From: Ferring Parish Council [REDACTED]
Sent: 17 March 2010 09:39
To: Planning.Responses
Cc: Bryan McCansh
Subject: Re: Please find attached amendment on planning application Ref: FG/5/10/

OBJECTION

REVISED ALTERATIONS & EXTENSIONS MARCH 2010

ROOF PLAN
1:200

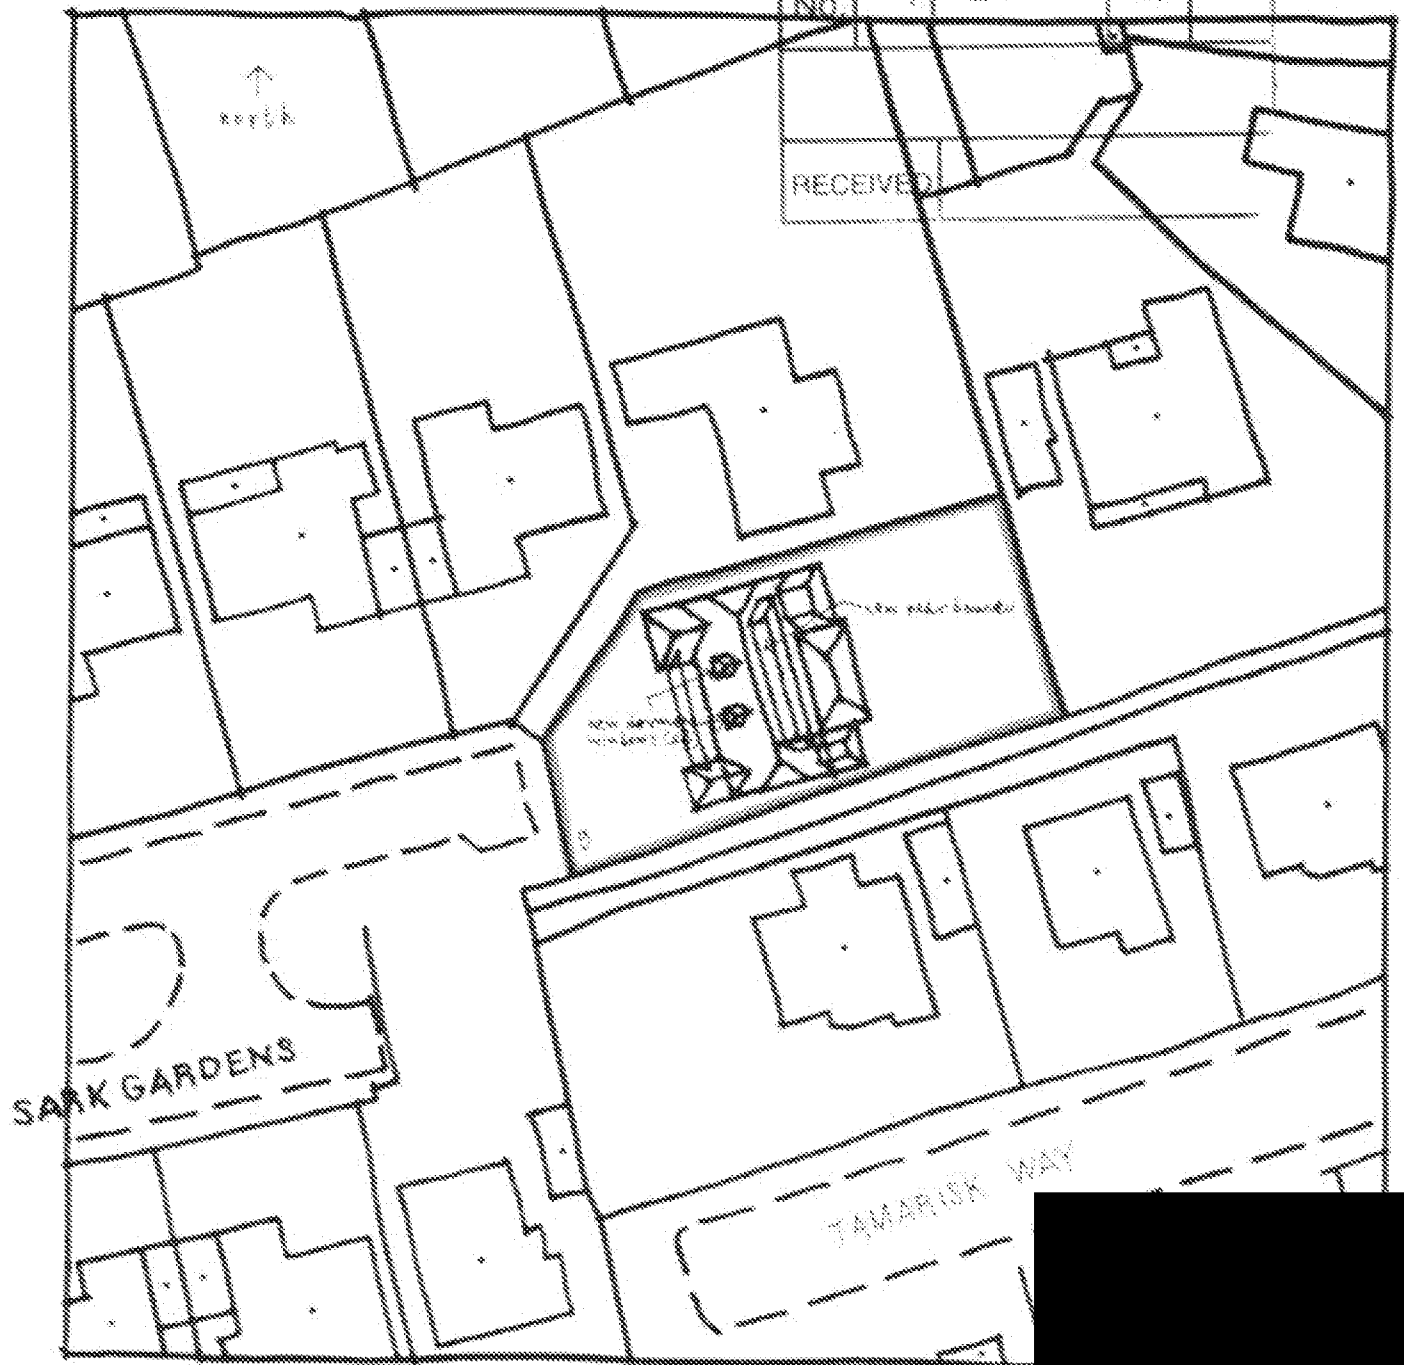
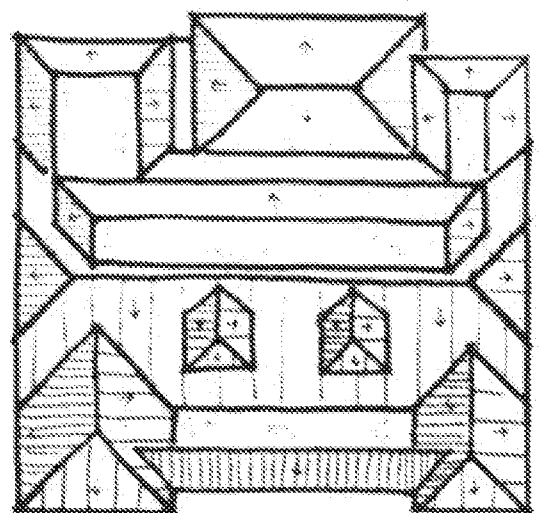
The provision of an increased roof area would doubtless cause further strain on an already inadequate surface water disposal system in this area and would be contrary to the provisions of Policy GEN 9 of the ADLP.

**GROUND FLOOR PLAN 1:100**

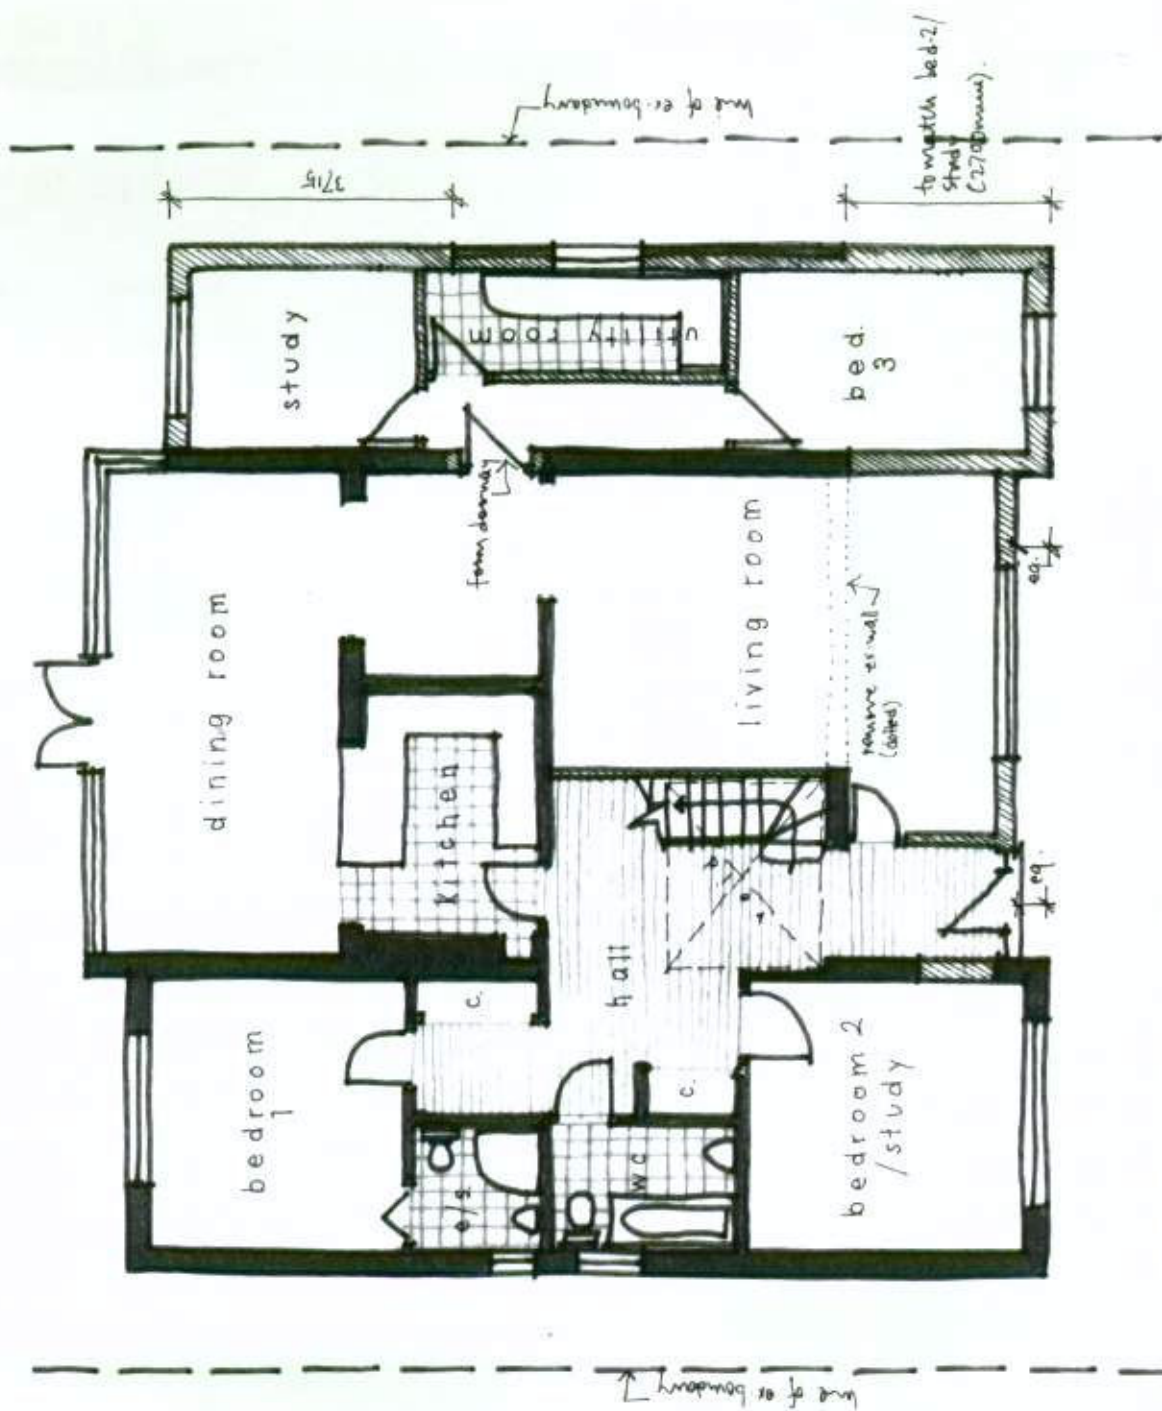
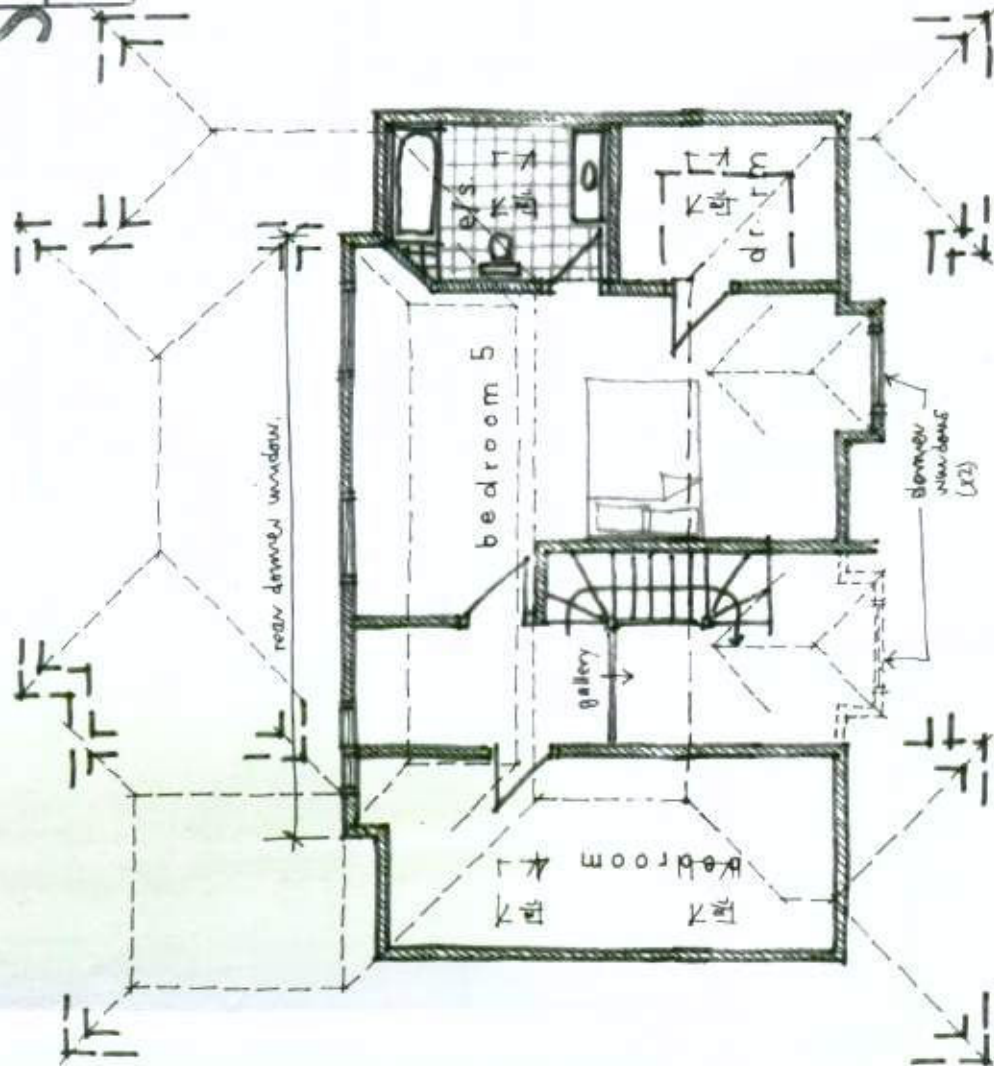
The nature of the area is such that the existing buildings are in close proximity to each other and the provisions of a high roof containing dormer windows would have an adverse impact on the adjoining premises in that they would overlook several gardens. All in contravention of the provisions of Policy GEN7 & DEV 19 of the Arun District Local Plan.

PROPOSED ELEVATIONS 1:100

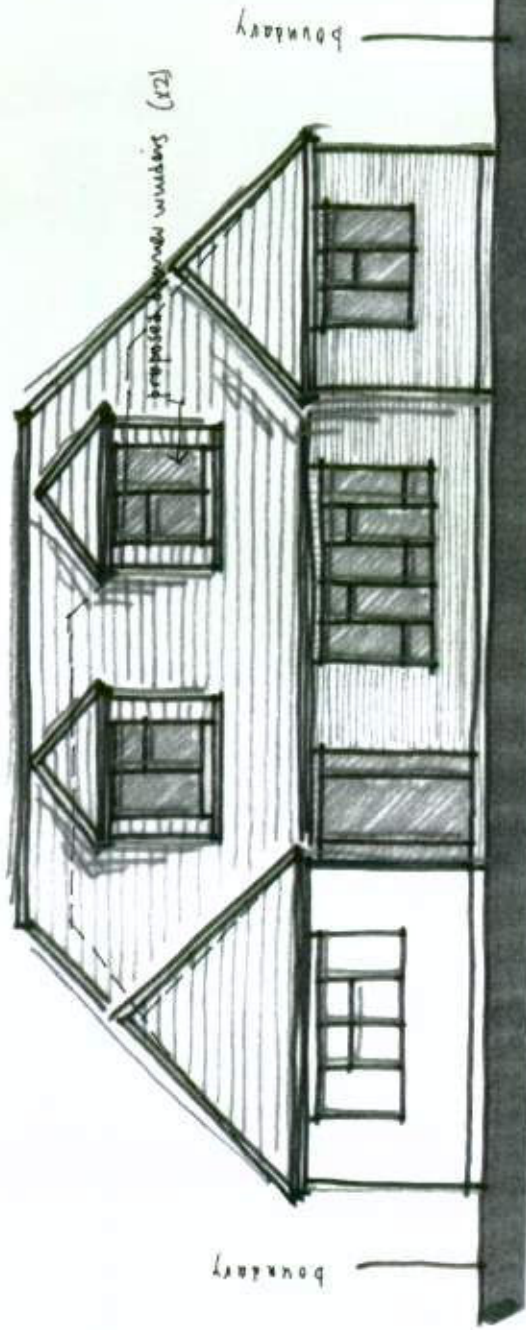
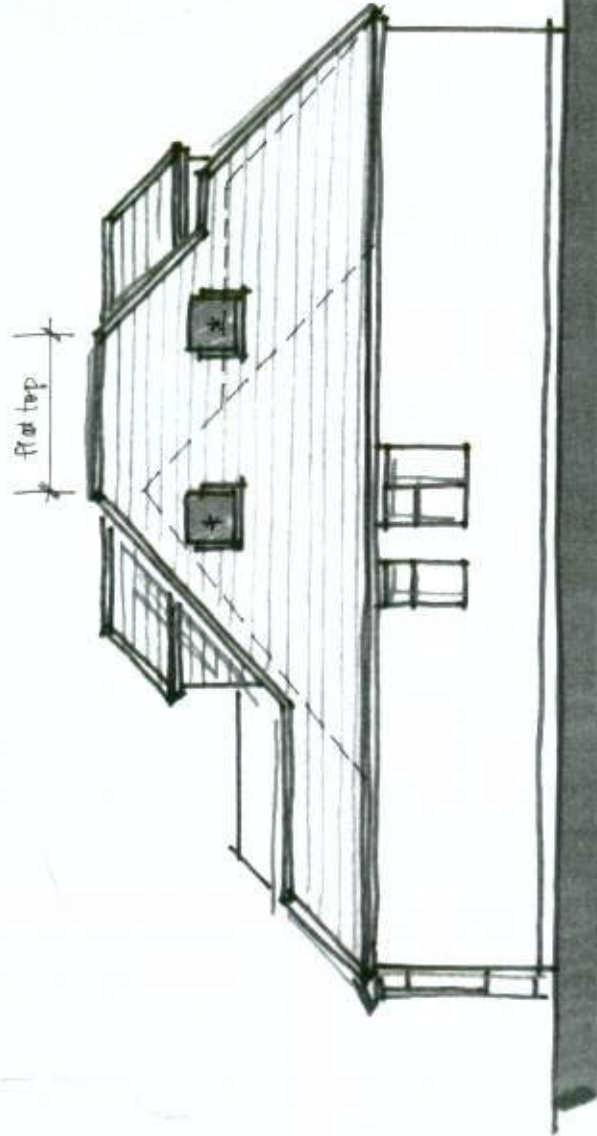
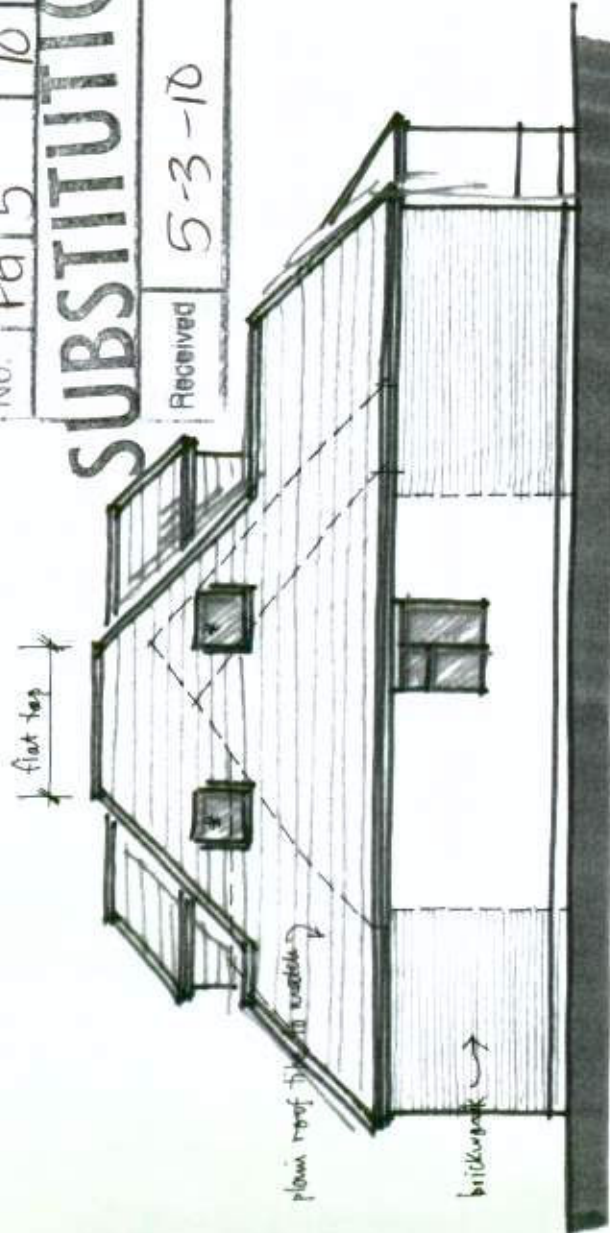
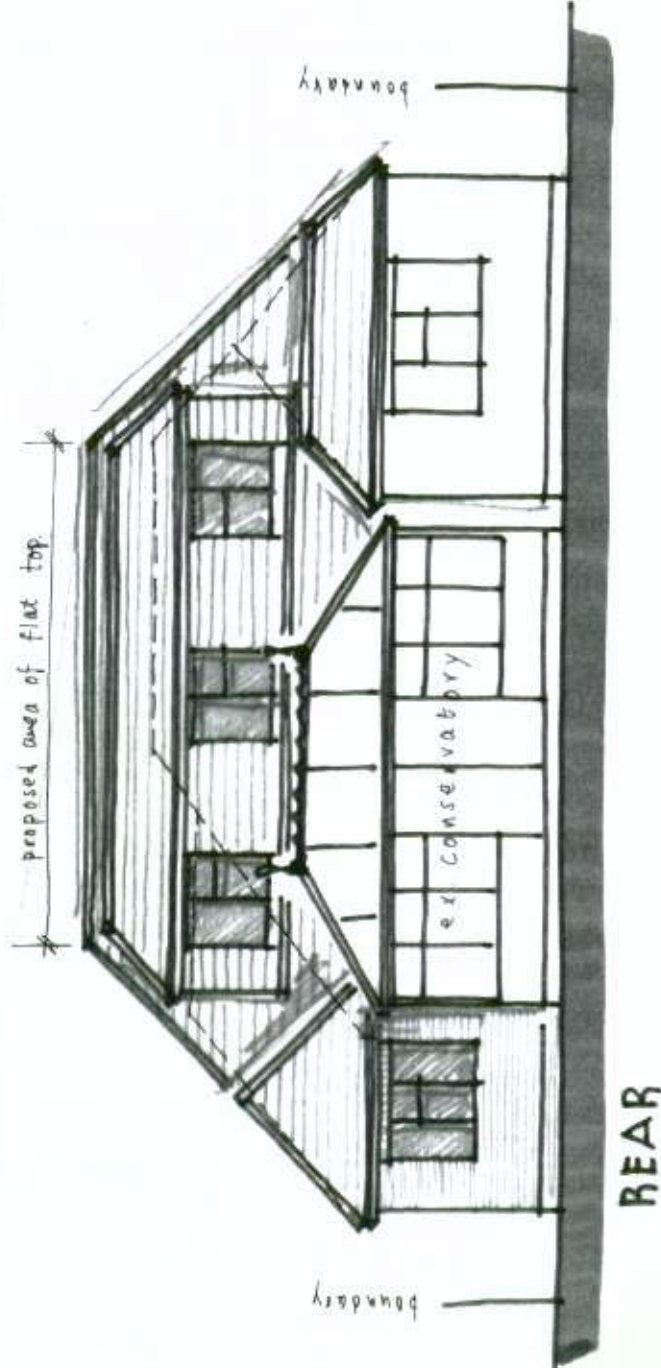
The revised proposals shown on the plans dated 5th March 2010 do nothing to address the previous concerns expressed by Ferring Parish Council which reiterates its strong objection to them in that the proposed extension and alterations to the roof would not be in accordance with the characteristics of the surrounding area and would be overbearing in the small close and form an incongruous feature in the locality where the buildings are predominantly bungalows.
